Grandview Reserve Phase 1
 Traffic Impact Analysis
 PUDSP-21-010
 (LSC #S214240)
 December 10, 2021

**LSC Responses
 to Comments**
3/11/2022

LSC Responses to TIS Redline Comments

Figure 2

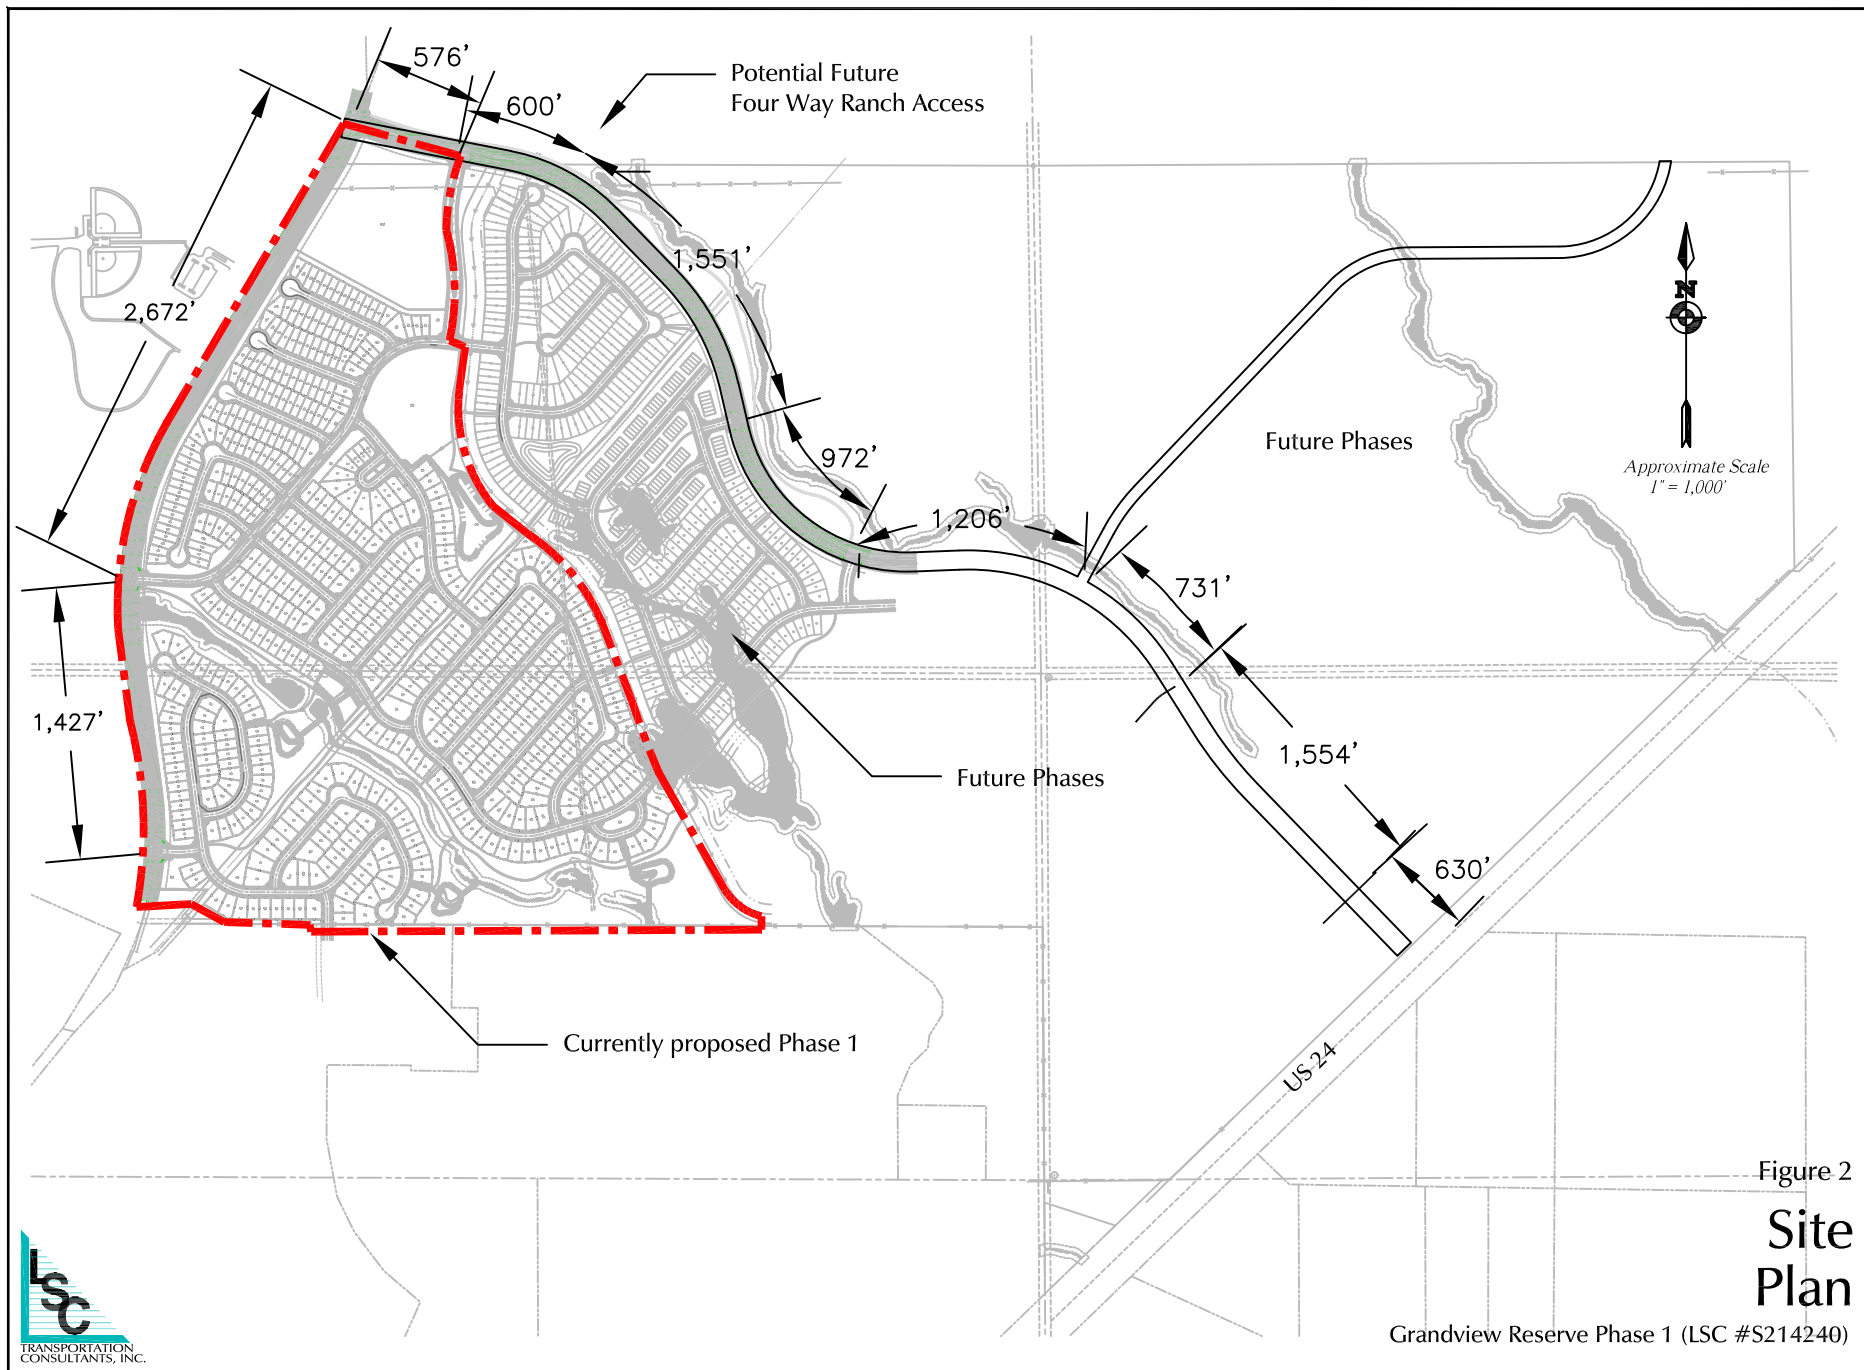
📄 Number: 3 Author: Paul Brown Subject: Highlight Date: 12/29/2021 15:42:18
Figure 2

Could not locate Figure 2 of proposed trails

LSC Response: The figure has been updated to show the proposed trail in green so they are
more visible
